Abram Tanus
P311/287 Pyrmont St
Ultimo NSW 2007

8 May 2013

Re: SSD 5752, Sydney International Convention, Exhibition and Entertainment Precinct.

ICC CONVENTION

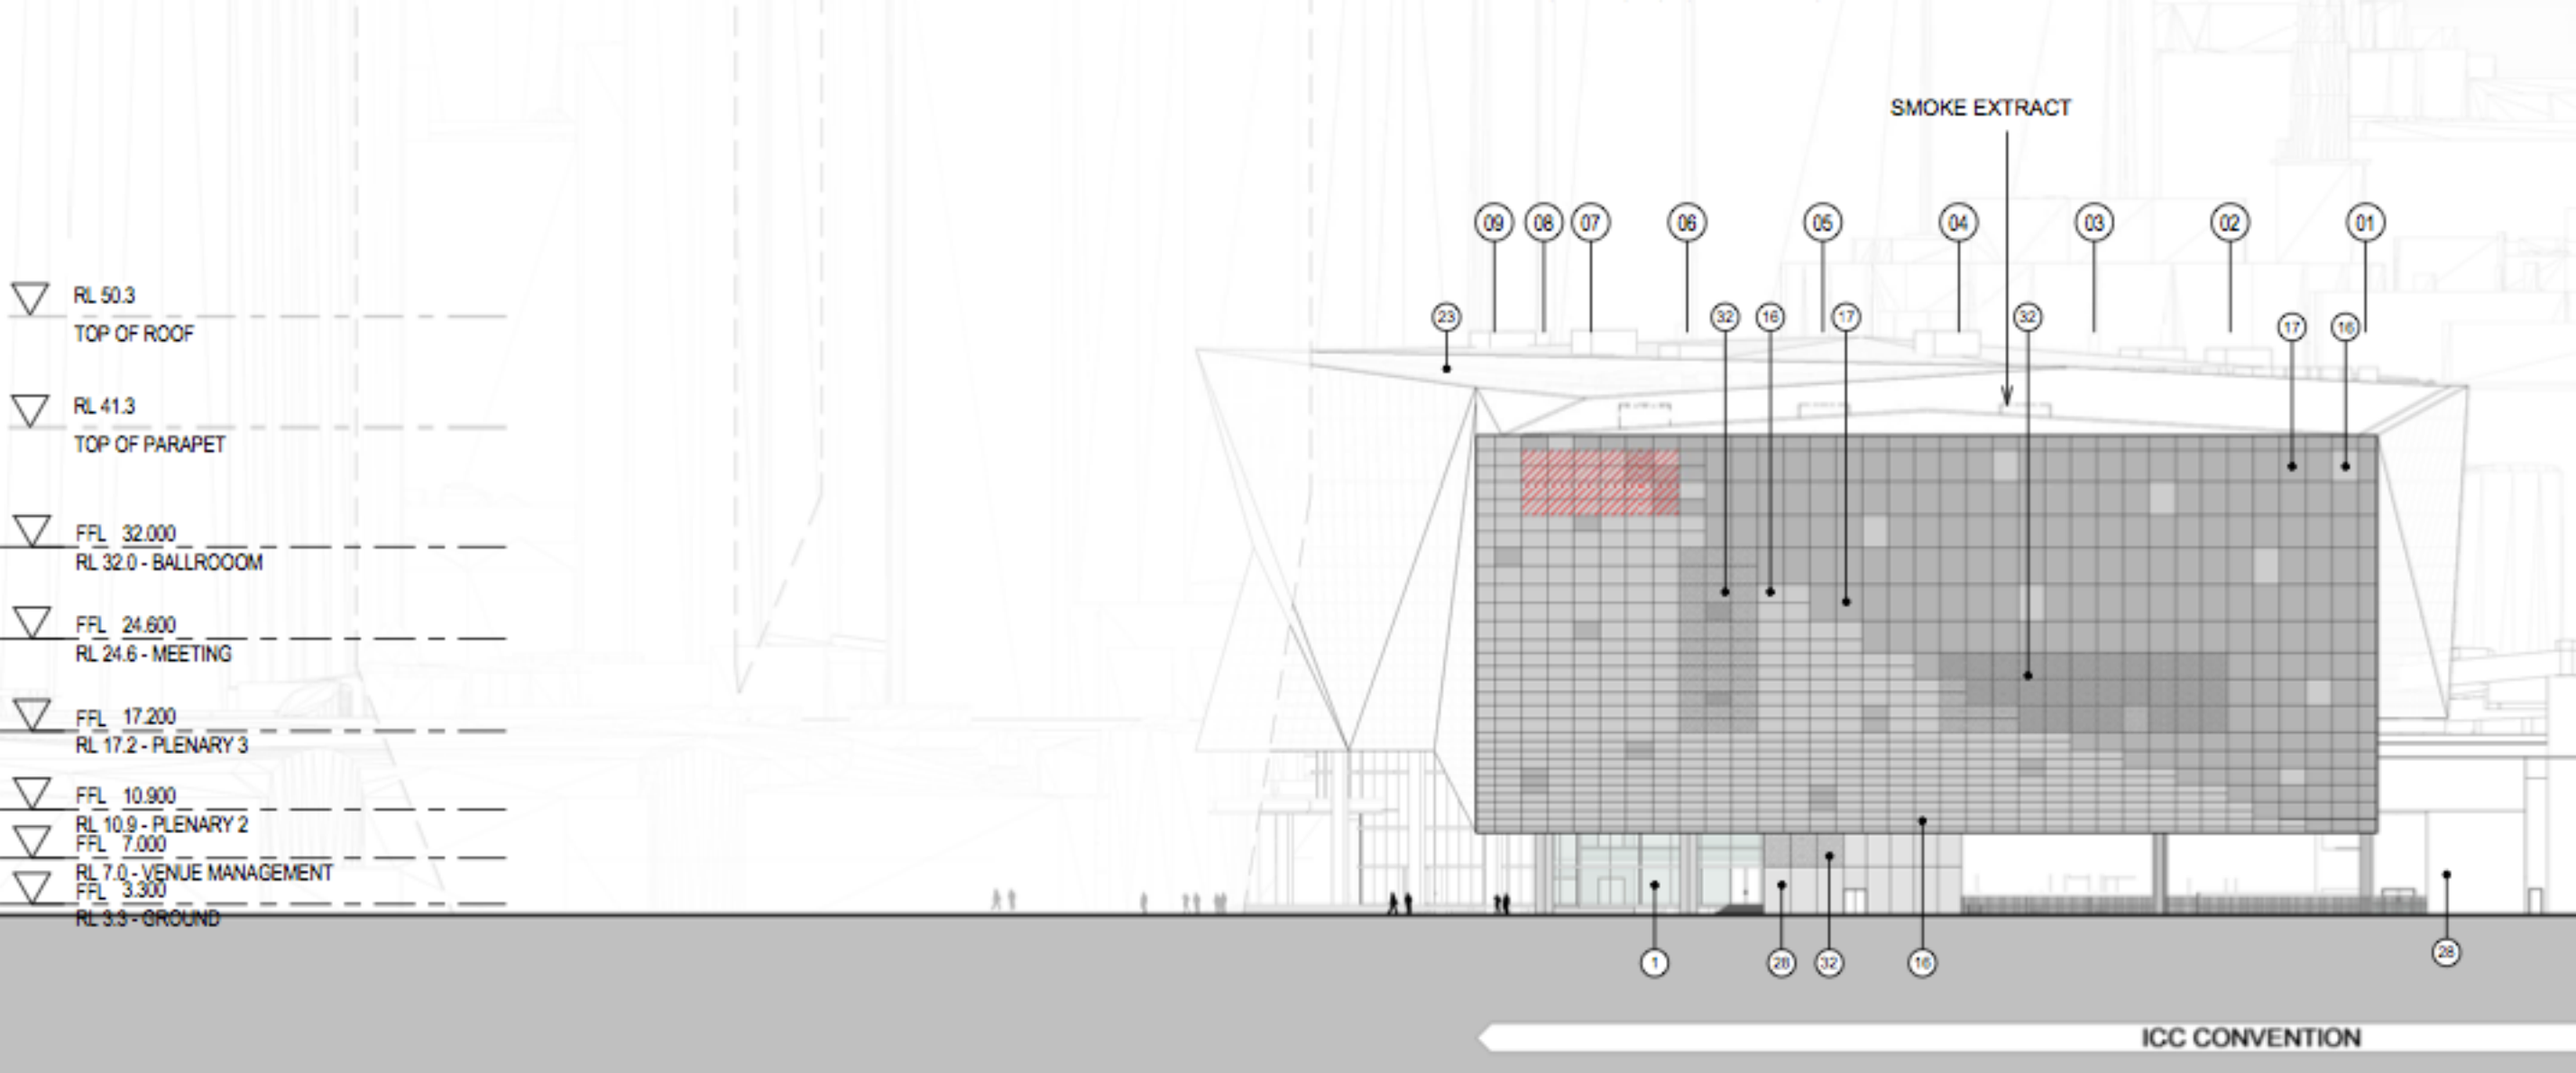
Unlike the front side, the rear side of the proposed two level exhibition centre looks like an industrial warehouse (figure 7). From Ultimo's side, it appears not quite in keeping for a world class facility in a premier location. Examples are the metal cladding of the truck ramp and the massive high wall along the event deck. They will reflect noise from the deck and Tumbalong Park. There are also reflective issues from the morning and afternoon sun.

The architects using creative designs and materials can improve the appearances, reduce the scale of the walls, and reduce reflectivity issues. This can also be said with the rear side of the proposed Theatre (figure 2).
